PORTLAND MAINE

February 25, 2010

Re: 142 Hennessy Drive – 347 B028 – R-3 – permit #10-0163 – farmer's porch

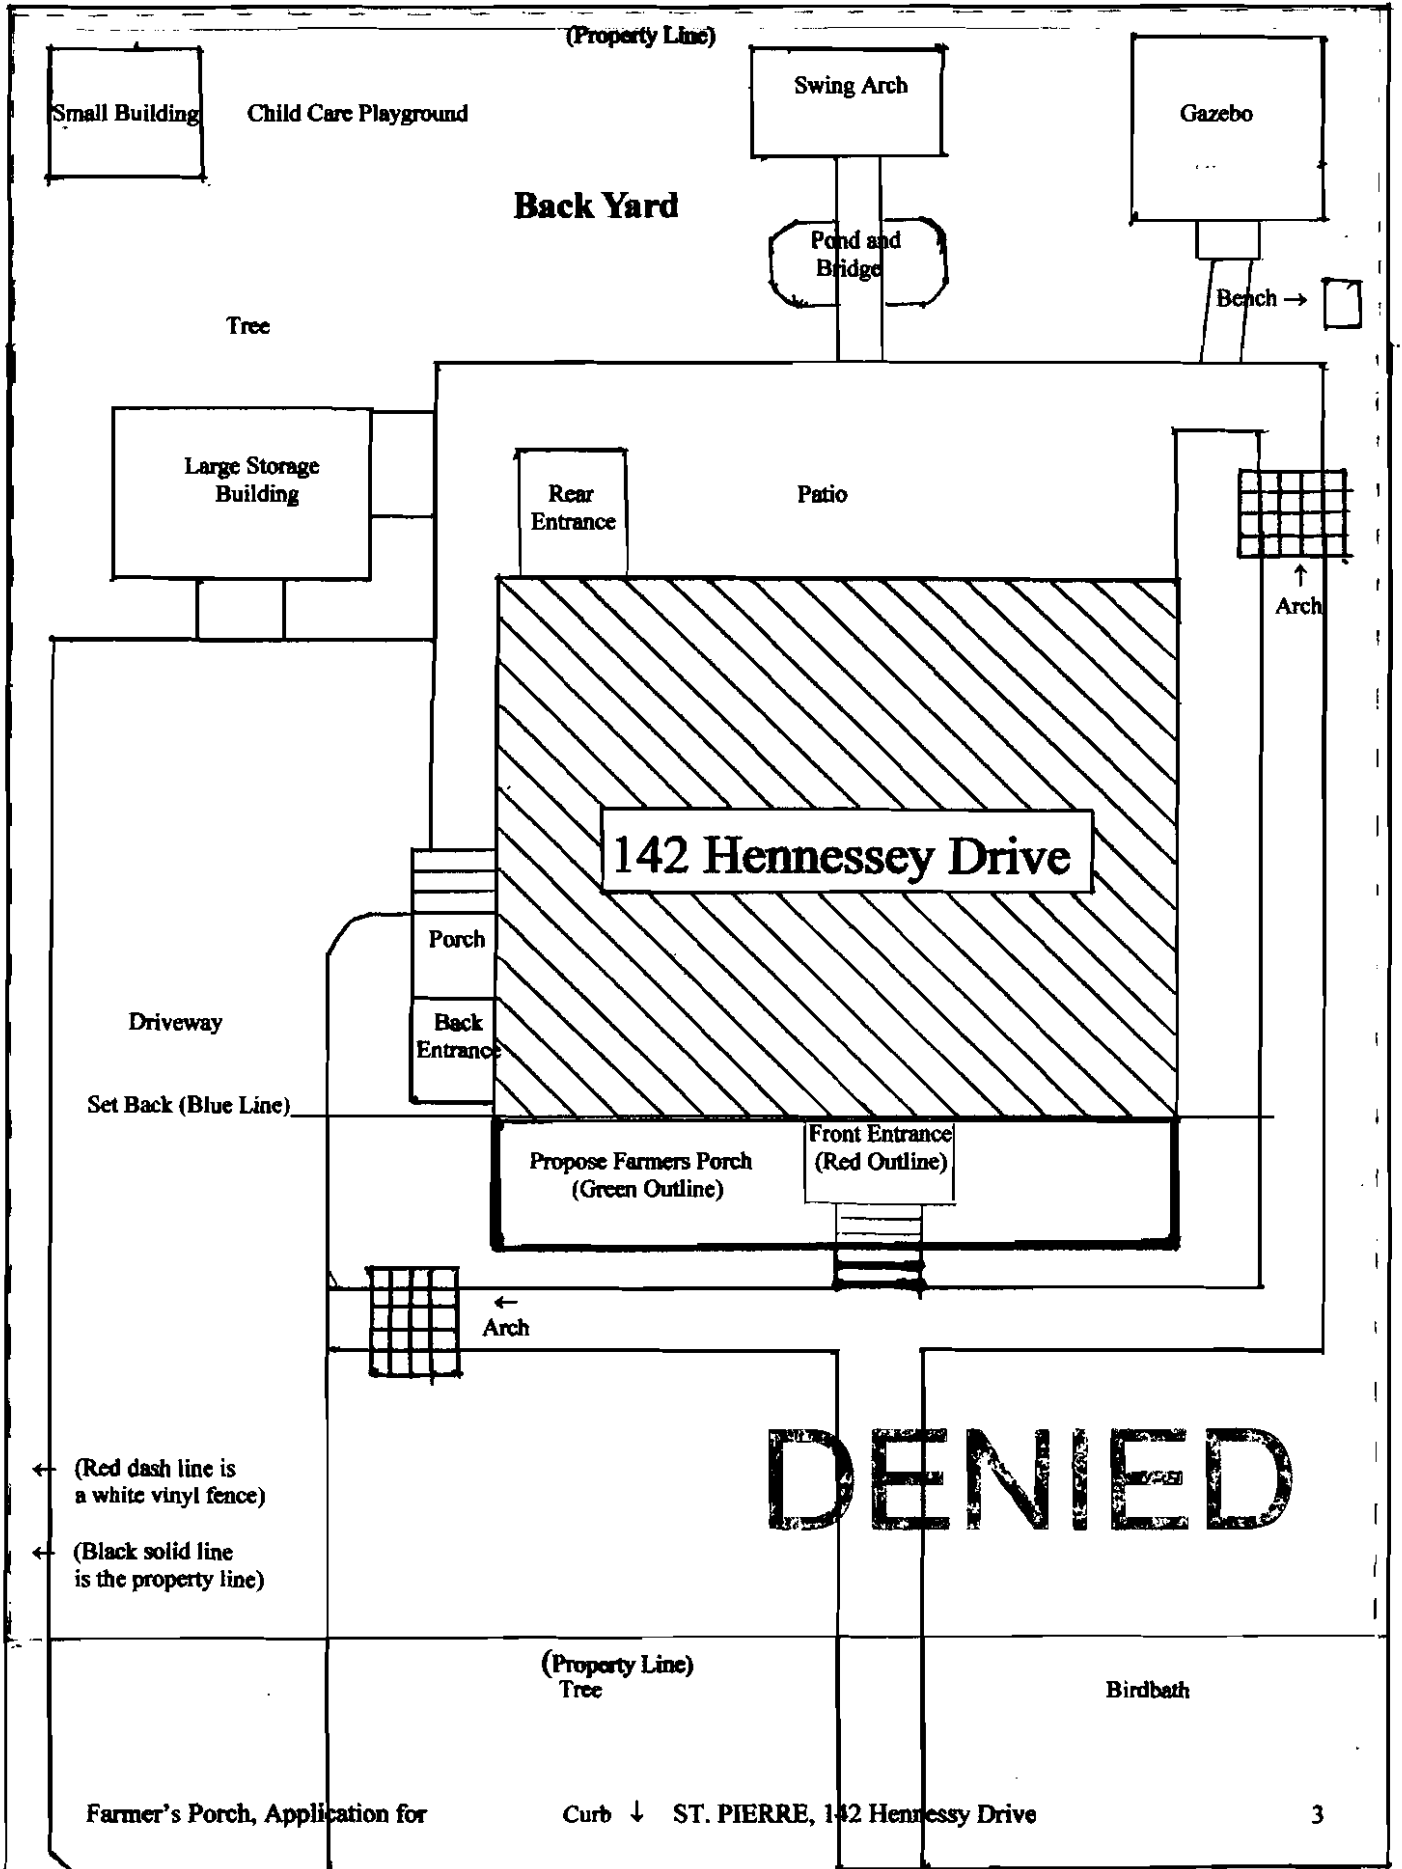
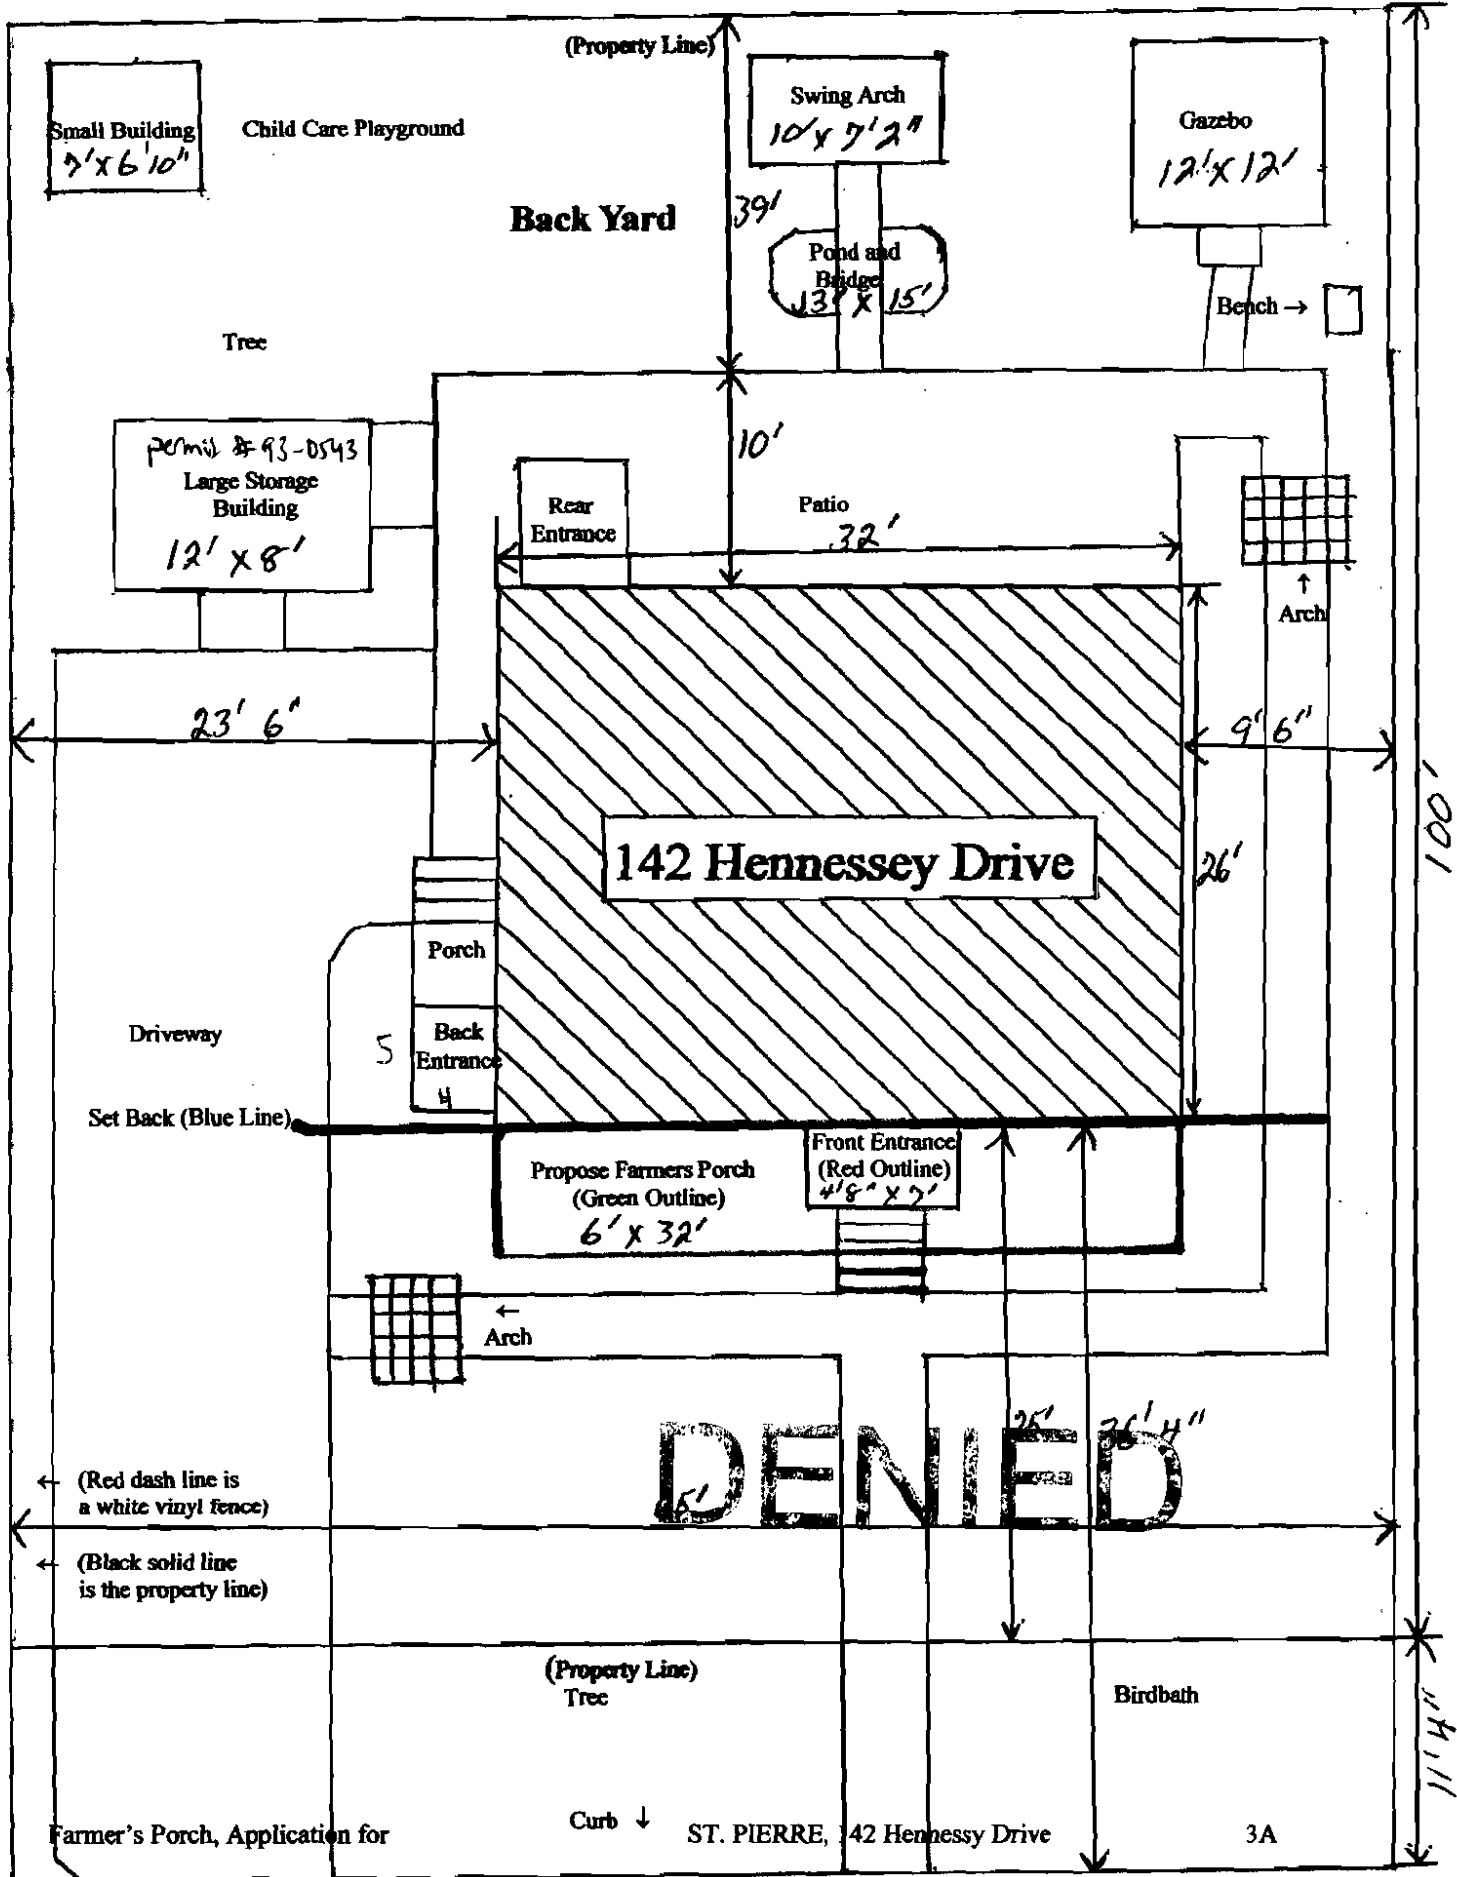
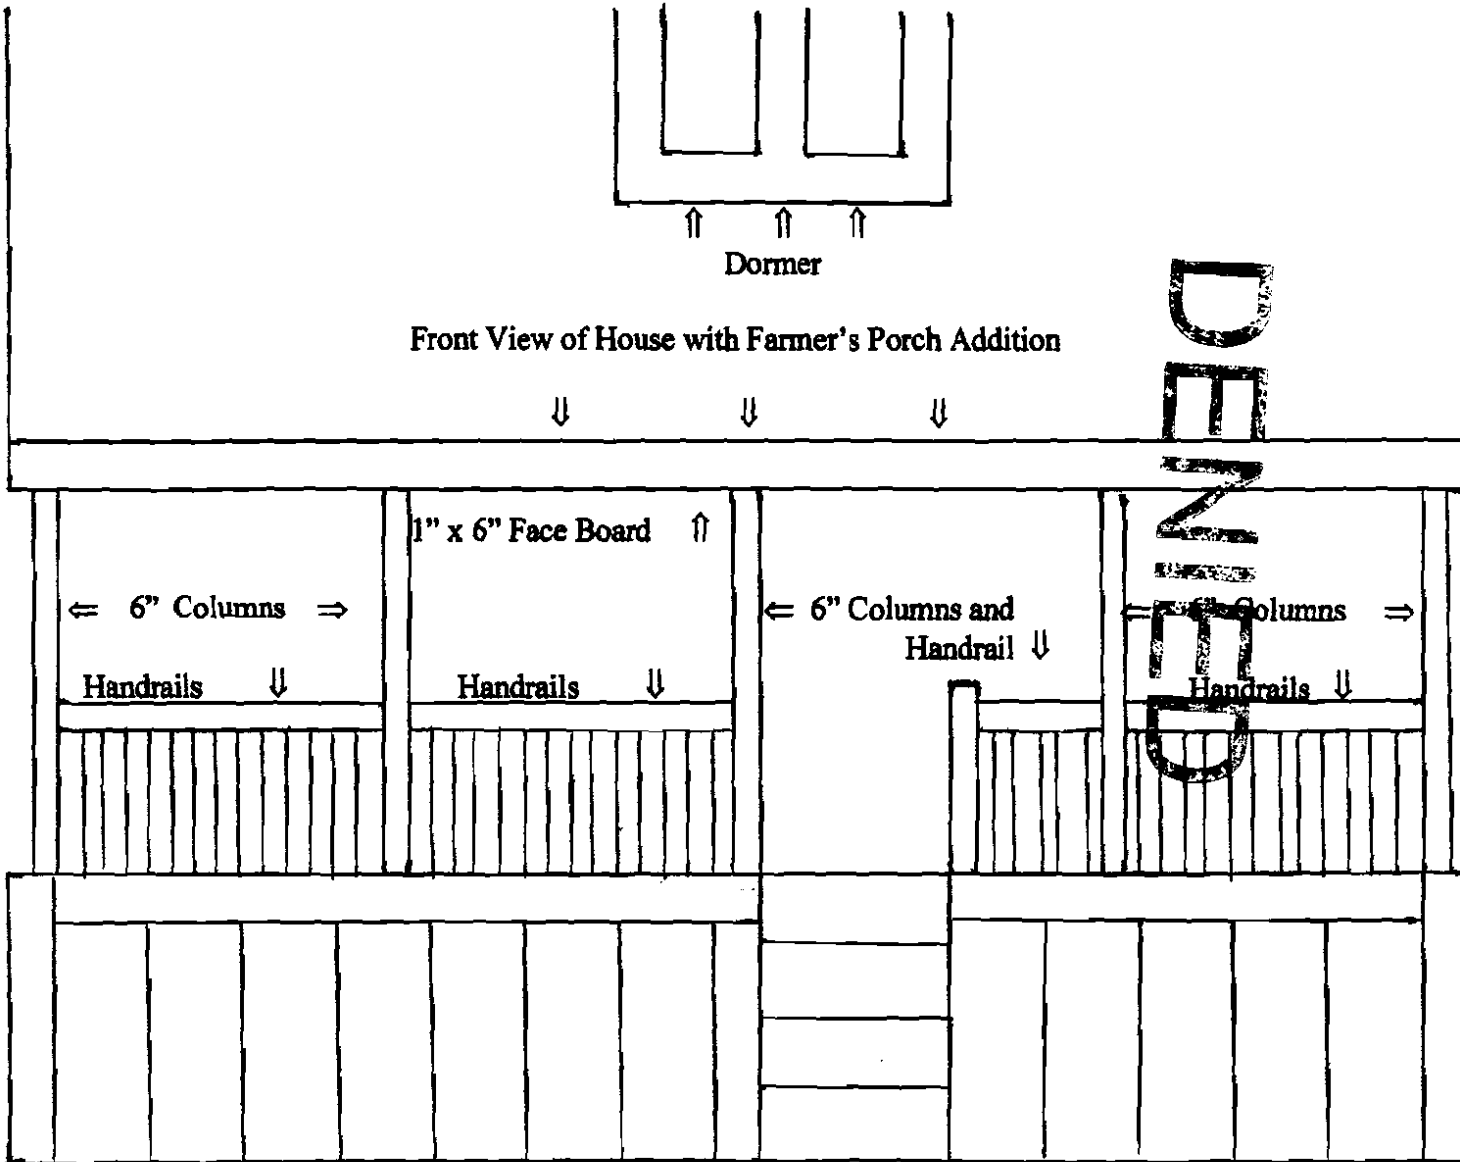
142 Hennessy Drive is located in the R-3 residential zone. The minimum required front yard setback is twenty five (25) feet [section 14-90(d)(1)]. The setback for the proposed farmer's porch is nineteen (19) feet from the front property line and the front steps encroach even further. Under section 14-425, an entry porch can project into a setback as long as the porch does not extend more than six (6) feet from the building and the total square footage of the porch cannot exceed fifty (50) square feet. The square footage of the proposed farmer's porch is 192 square feet, so it does not meet the criteria of the section. Since the proposed farmer's porch does not meet sections 14-90(d)(1) and 14-425, the permit is denied.
